Project # 1003102

DEVELOPMENT REVIEW BOARD--SPEED MEMO

DRB CASE NO/PROJECT NO: 1003102

Re: Project #1003102, 09EPC-40029 SDP Building Permit – La Vida Llena

1 Site Plan  
SCALE: 1" = 20'

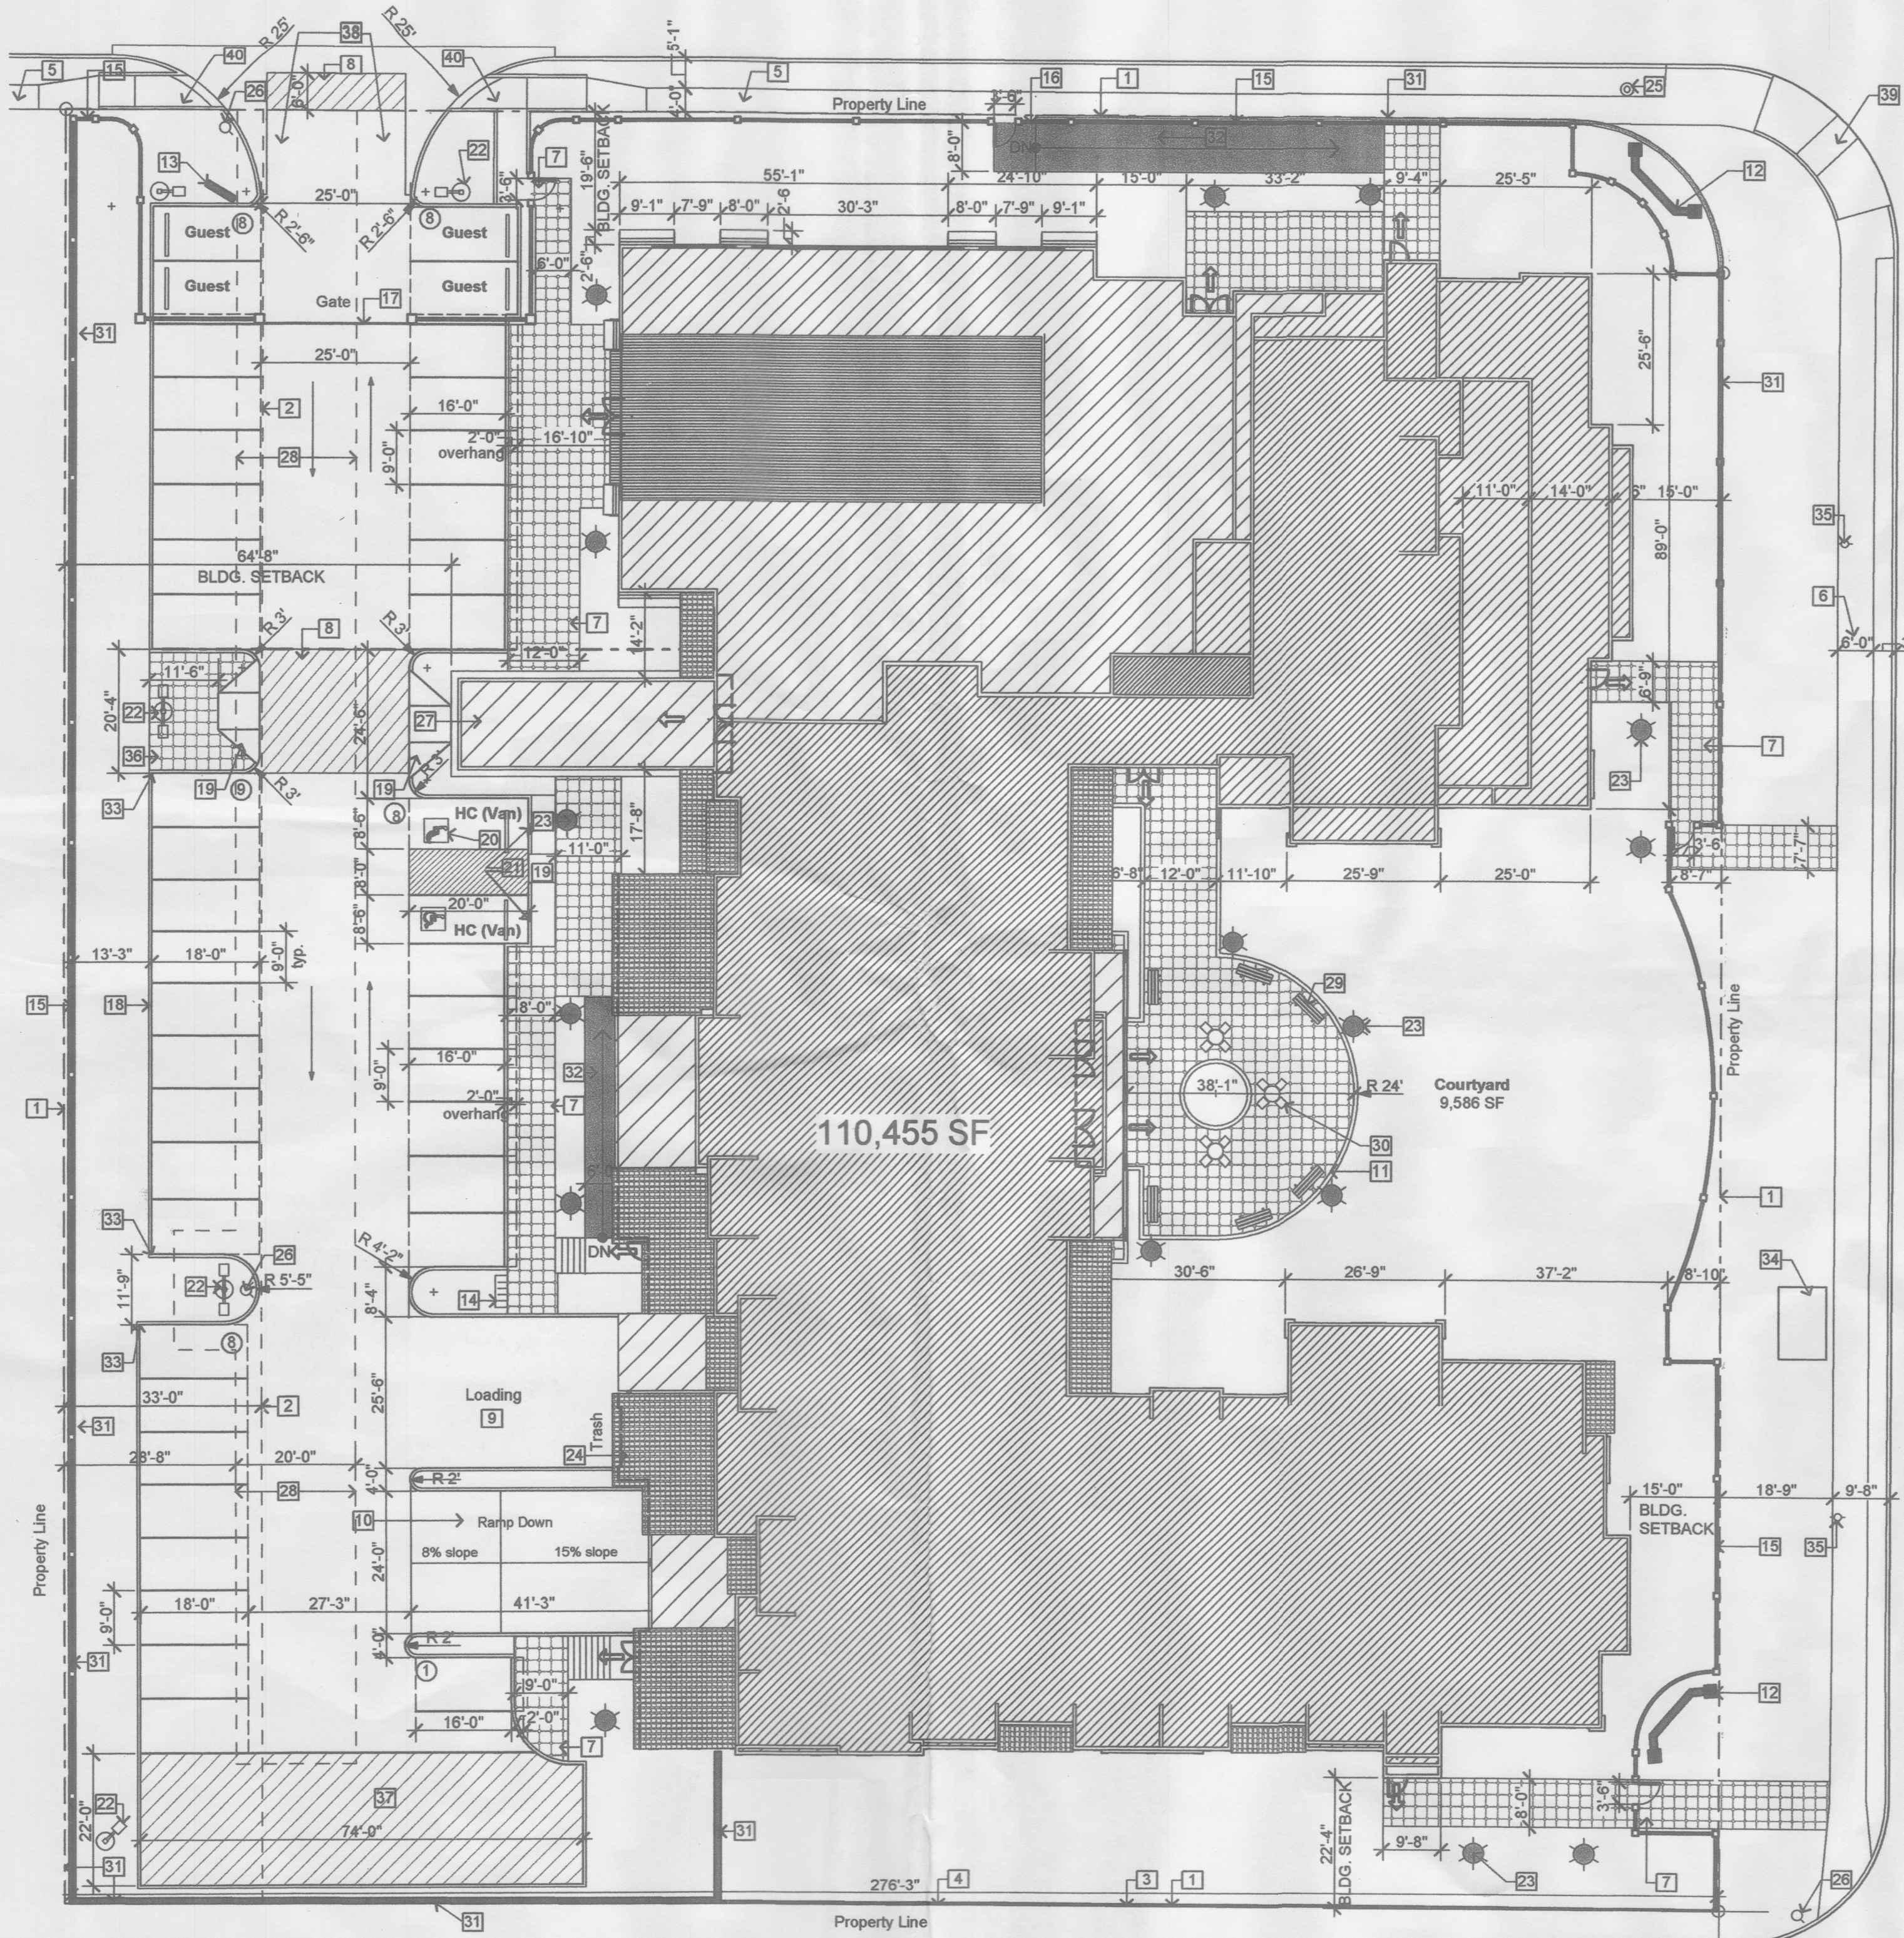
All proposed ramps located within the public right of way must have truncated domes.

Build notes, referring to the specific City Standard, must be provided for all proposed items within the City right of way (curb and gutter, ramps, sidewalk, curb cuts, etc.).

The proposed metal fence/CMU retaining wall may interfere with the sight distance of the entrance. See the *Development Process Manual*, Chapter 23, Section 6, Part B.12. Provide a sight triangle exhibit.

The handicapped spaces must include an 8-foot wide van access aisle

Call out the width and length for all parking spaces.

Call out the width of the pedestrian gate (note the gate must be a minimum of 3 feet in width).

Label the compact parking spaces by placing the words “compact” on the pavement of each space.

Clearly demonstrate the 6-foot wide, ADA accessible, pedestrian pathway from the roadway to the building.

All sidewalk within the site should be a minimum of 6 feet in width.

Provide additional information regarding the proposed gate. When will the gate be open? If the gate is closed and guest parking is full, how will cars maneuver out of the site?

How is ADA accessibility maintained across the loading and ramped areas?

**LANDSCAPE CALCULATIONS**

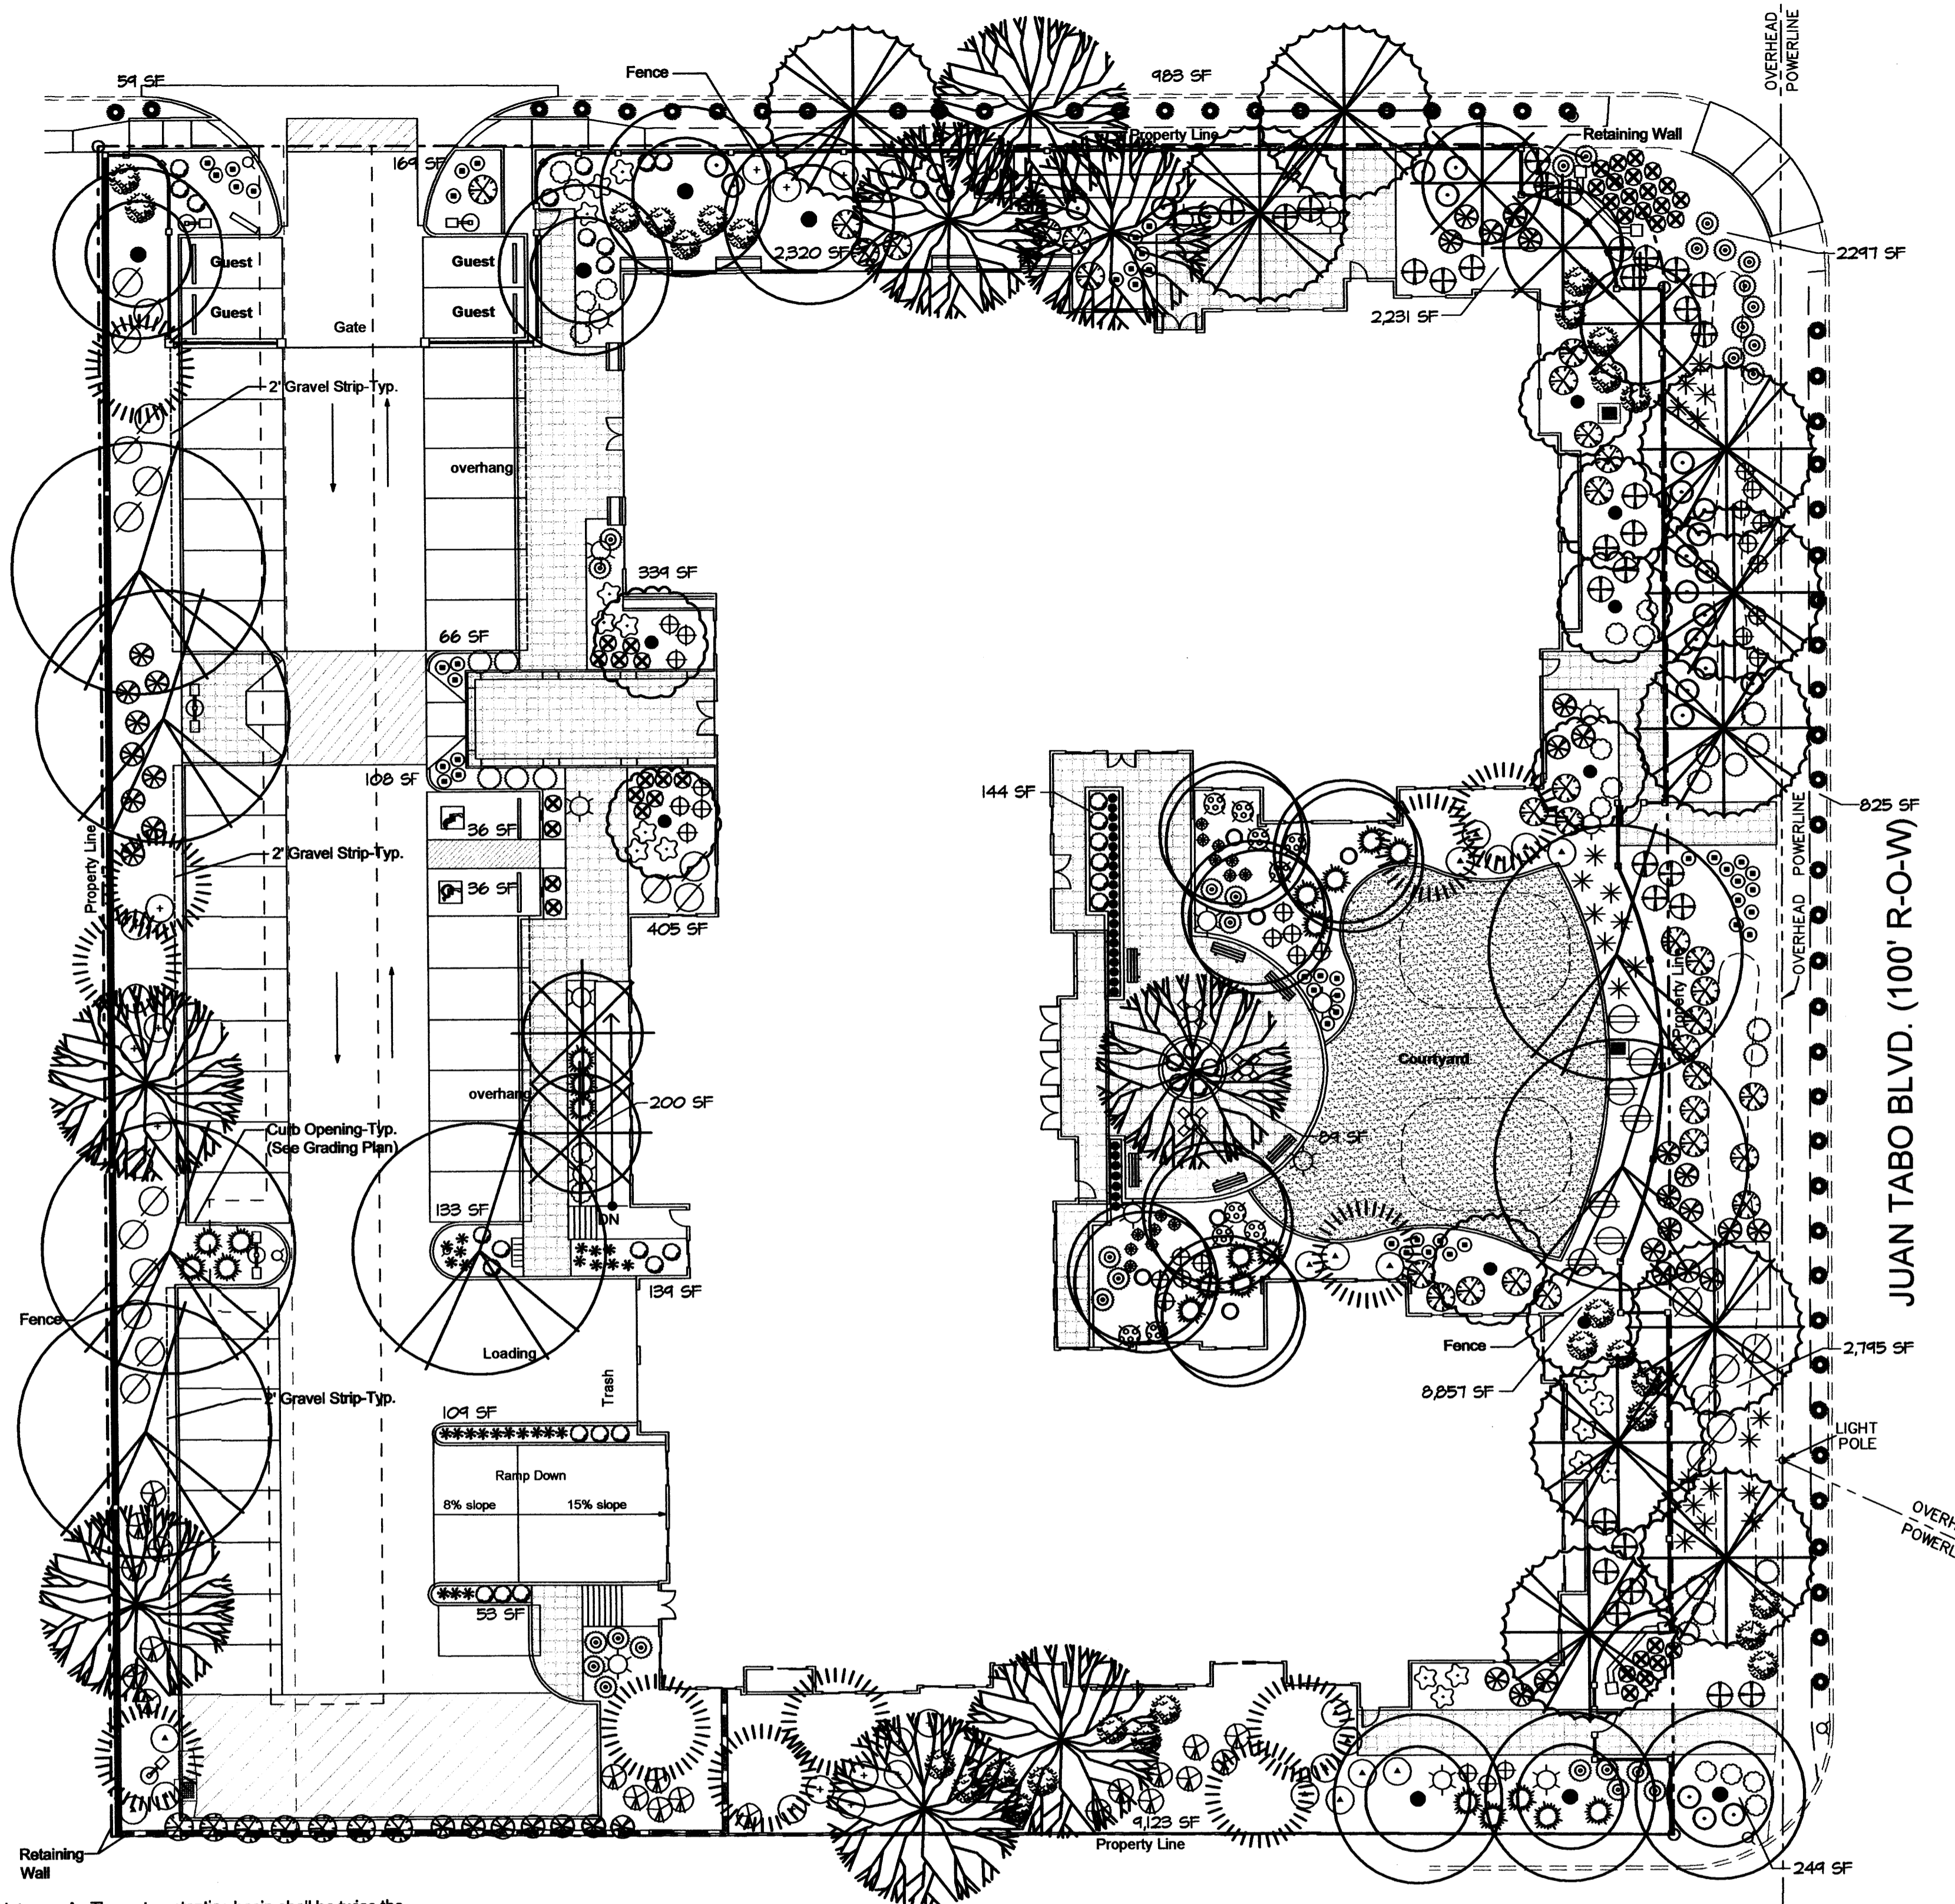
- One tree at the southeast corner of the building (a Robinia) must be moved further than 4' from the façade.
- The triangular landscaped beds on either side of the west entrance must be retained even if the tree in each bed is eliminated.

Retaining wall in southeast corner of site – the DRB Grading & Drainage plan shows a new N-S extension between the property line and the southwest corner of the building. This extension also needs to be shown on the SDPBP and the Landscape Plan (Sheets 1 and 4).

Curb openings – the openings that allow runoff into landscaped beds along the west row of parking should be shown and called out on the landscape plan (they were shown on the EPC landscape plan).
